From: [Guymer, Tim](#)
To: [Aquind Interconnector](#)
Cc: [Drury, Holly](#); [Stickland, Caroline \(Solicitor\)](#); [Murray, Chris \(Planning\)](#); [Richard Turney](#)
Subject: EN020022 Aquind Interconnector - Deadline 6 submission from Hampshire County Council (Reference: 20025080)
Date: 22 December 2020 14:50:24
Attachments: [HCC Oral Transcript - 9th Dec ISH1 DCO Hearing.pdf](#)
[HCC Oral Transcript - 10th Dec CAH1 Hearing.pdf](#)
[HCC Oral Transcript - 14th Dec ISH2.pdf](#)
[HCC Oral Transcript - 15th Dec ISH3 Hearing.pdf](#)

December 9th – AQUIND ISH1 - DCO Hearing – HCC Transcript & Post Hearing Note/Transcript

December 10th – AQUIND CAH1 Hearing – HCC Transcript & Post Hearing Note/Comment

December 14th – AQUIND ISH2 Hearing – HCC Transcript & Post Hearing Note/Comment

TITLE: **Figure 3.12  
Construction Corridor Assumptions  
HVDC Cables - Highway  
Sheet 1 of 2**

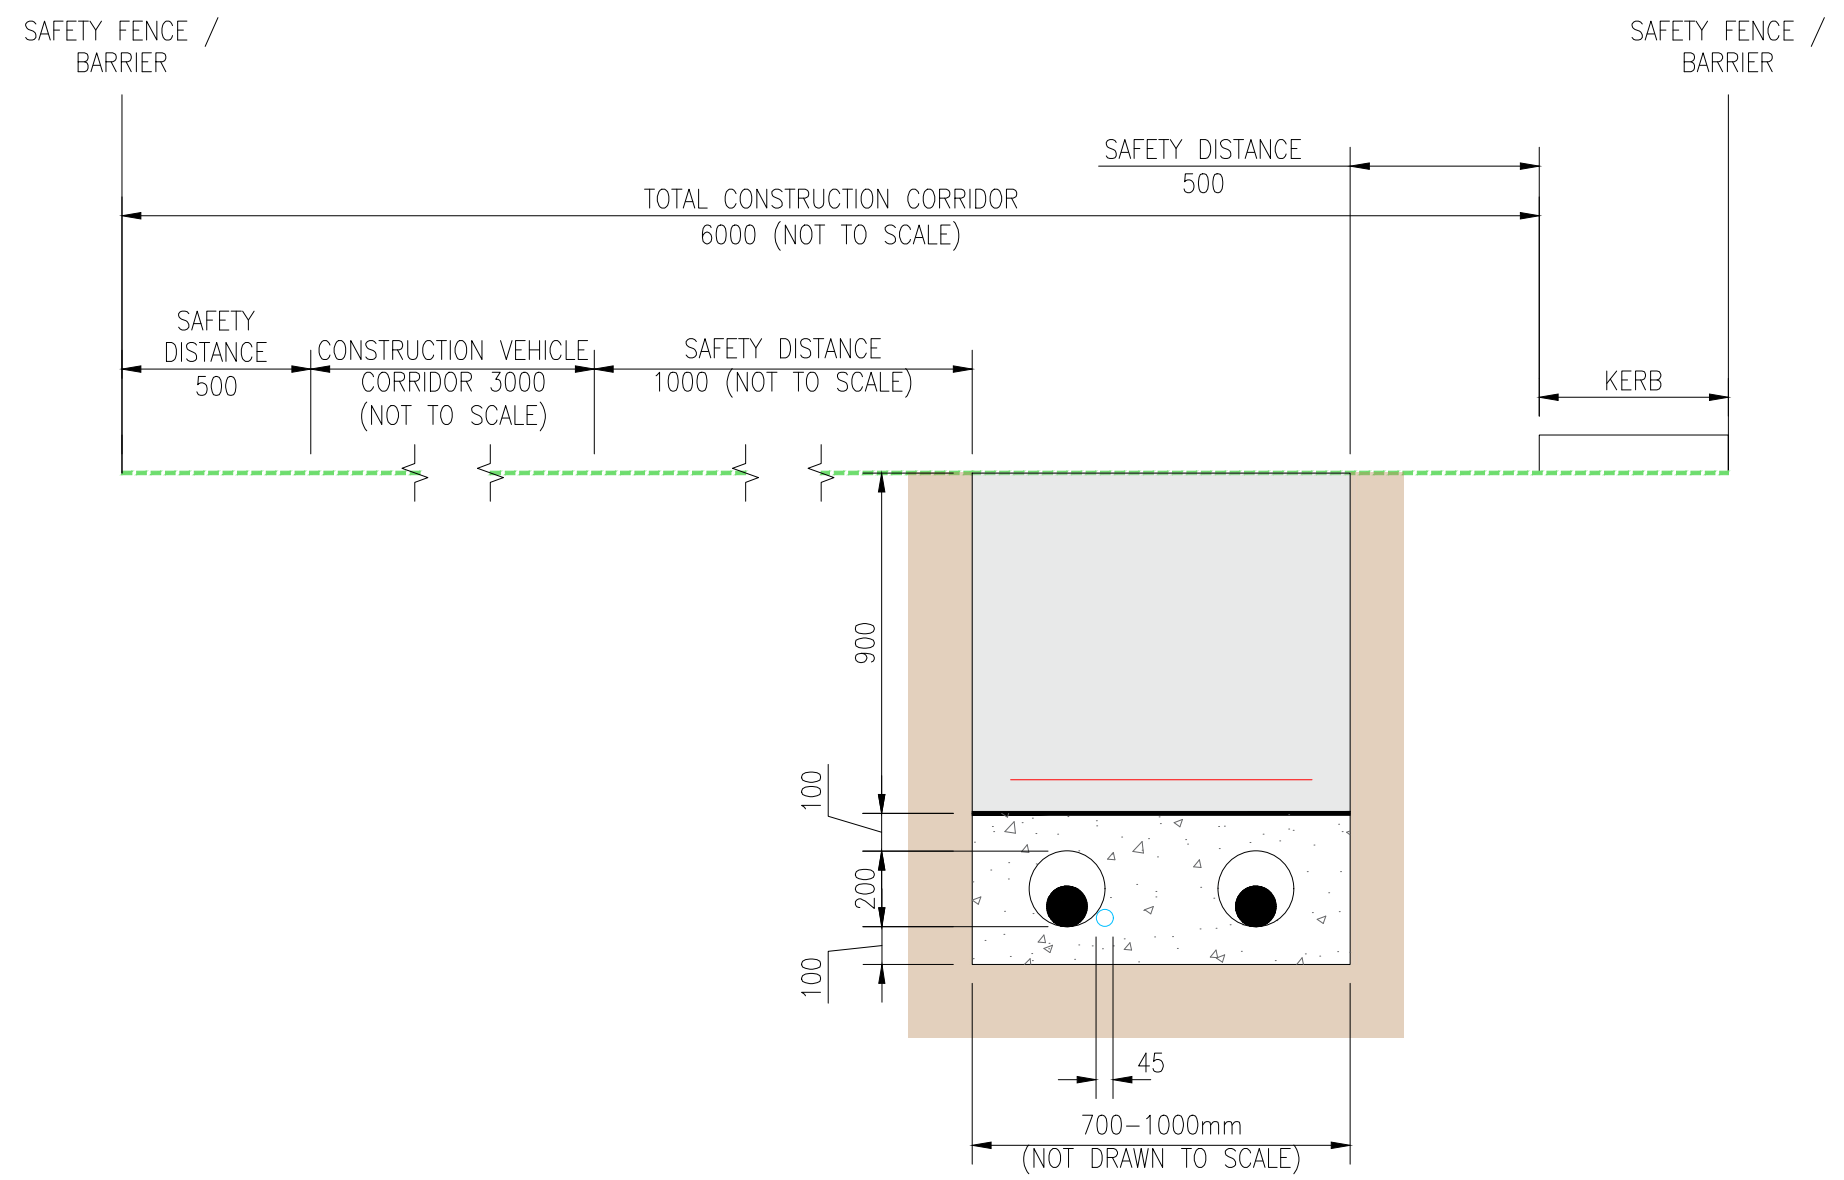
3.17	Is there intended to be a difference between installation/ construction, operation and maintenance rights under Articles 23 and possibly 20, or would the corridor rights, of approximately 6 and 23m in width, shown in ES Vol 2, Fig 3.12 [APP-157] remain in perpetuity for each category? Is the corridor rights width restricted by anything in the dDCO apart from the Order limits? Would the dDCO prevent the undertaker installing further cables or ducts, either at the time of the initial installation or subsequently, under the description provided in the dDCO for Work No 4	HCC made no comment on this matter within the hearing. Post Meeting Comment – It is HCC’s understanding that the applicant is to provide a post meeting note regarding easement requirements. This is expected to provide clarity on when these will be necessary and an appropriate process as to how HCC will be made aware, and be party to, establishing if easements are required.
